Principal Issue in question	Concern held	What needs to change/be amended/be included in order to satisfactorily address the concern	Likelihood of concern being addressed during Examination
<p>E01: Overstatement of wider economic benefits of the proposal</p>	<p>TDC believes the level of increase capacity attainable from the NRP presented by GAL is overstated, leading to an overstatement of demand forecasts. TDC contests that the methodology used to derive these numbers is best practice or robust. As a result, the wider economics benefits of the proposal have been overstated and it is unclear that there is an economic case for the expansion of Gatwick.</p>	<p>Full modelling of the interaction between the use of the two runways and the respective departure routes needs to be undertaken and the delay information provided at a sufficiently granular level (hourly) to enable the delays to be properly understood and the capacity attainable validated.</p> <p>Robust market analysis and specific modelling of the share of demand that might be achieved at Gatwick in competition with other airports, not limited simply to traffic, including that from other regions of the UK, that has historically

Diagram 3.3.9: Model performance before and after adjustment, London zone

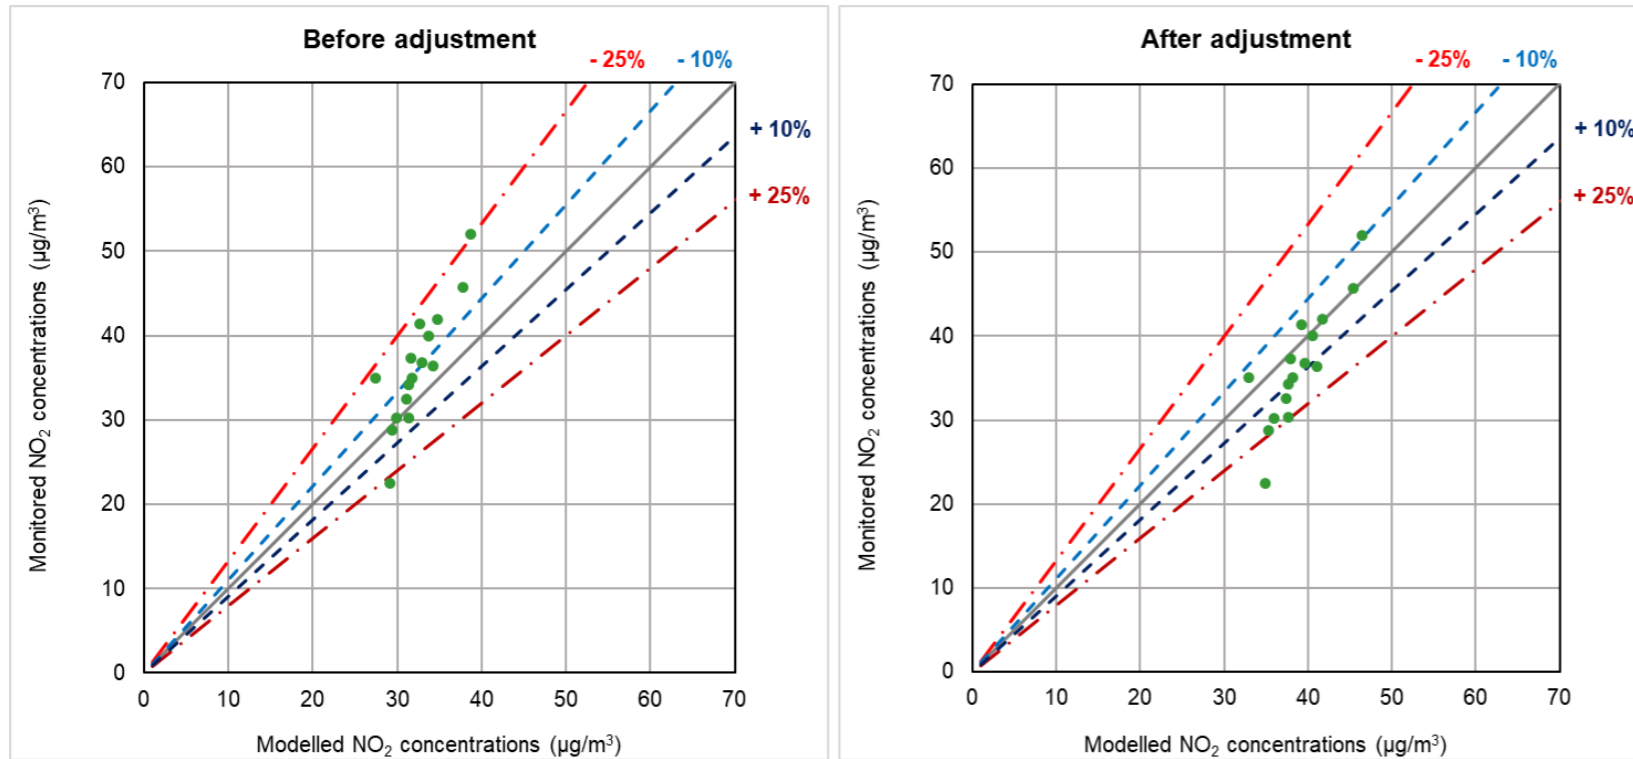
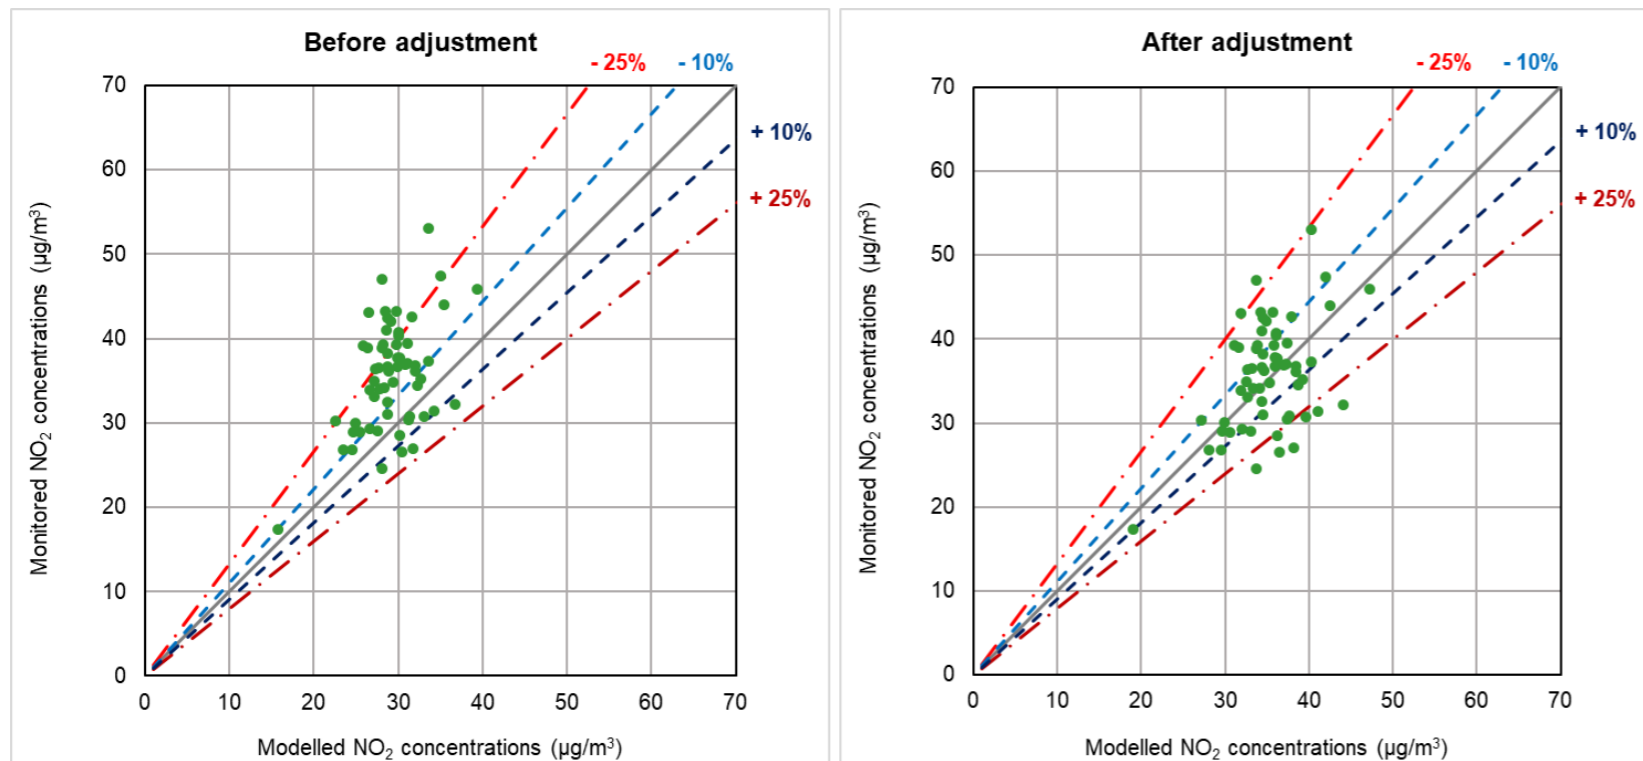
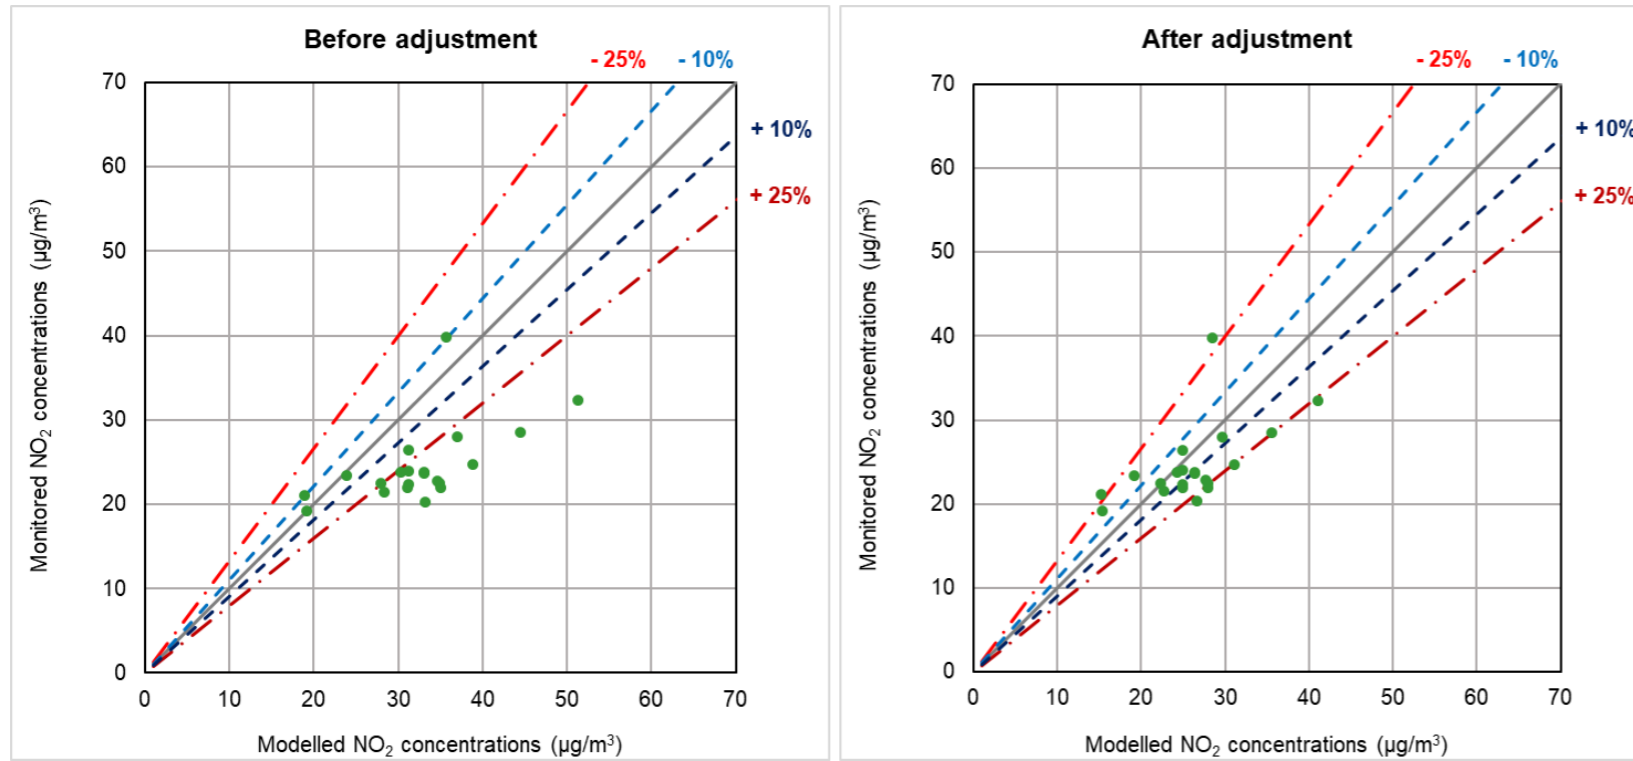
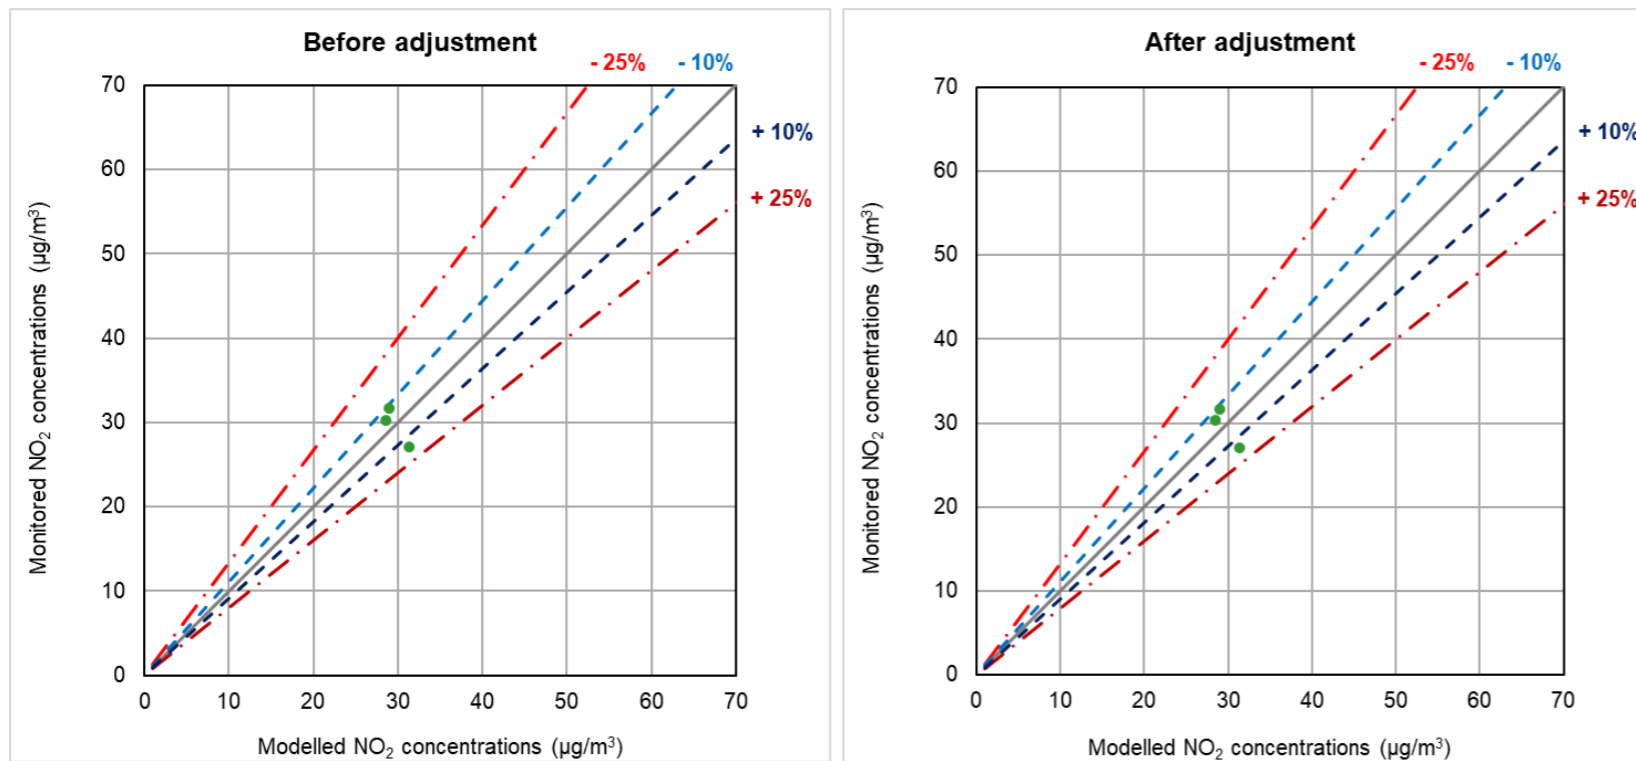
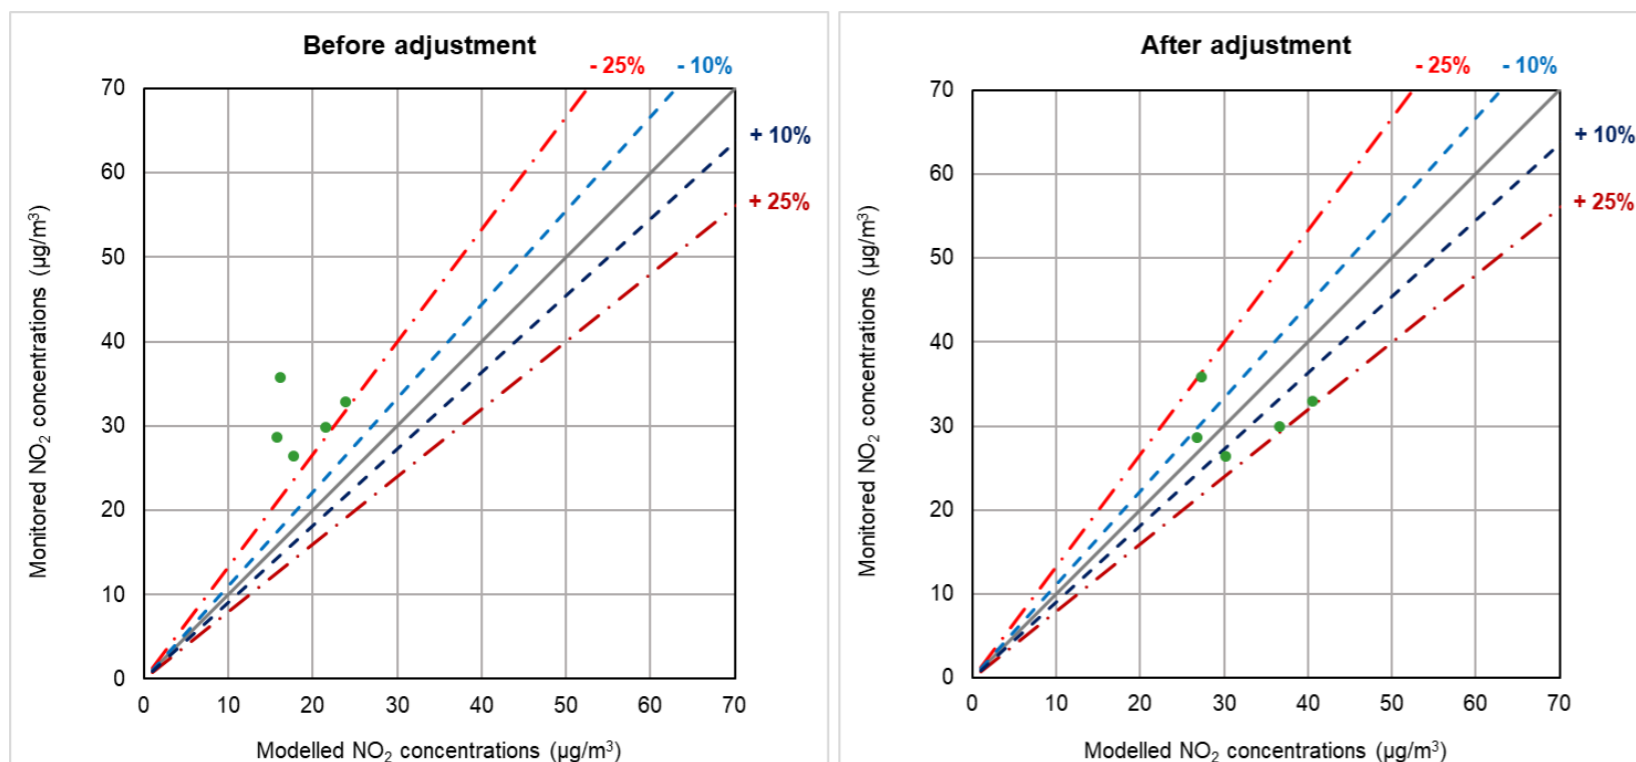
Principal Issue in question	Concern held	What needs to change/be amended/be included in order to satisfactorily address the concern	Likelihood of concern being addressed during Examination
AQ06: Monitoring sites	TDC is concerned that excessive numbers of monitoring sites may have been excluded from model verification which could have improved the quality of the air quality verification and so the confidence in outputs.	Further details on the sites excluded on this basis is required. Further details could be added to Table 3.2.2 of Environmental Statement Air Quality Appendix 13.6.1 to address the clarification points.	Uncertain
AQ07: Verification zones	TDC disagrees that enough justification was provided for the selection of different verification zones and why the model would be expected to perform differently in each area. A sensitivity test is required to demonstrate that the conclusions of the assessment would not change if a single verification factor were used.	A sensitivity test is required to demonstrate that the conclusions of the assessment would not change if a single verification factor were used.	Uncertain
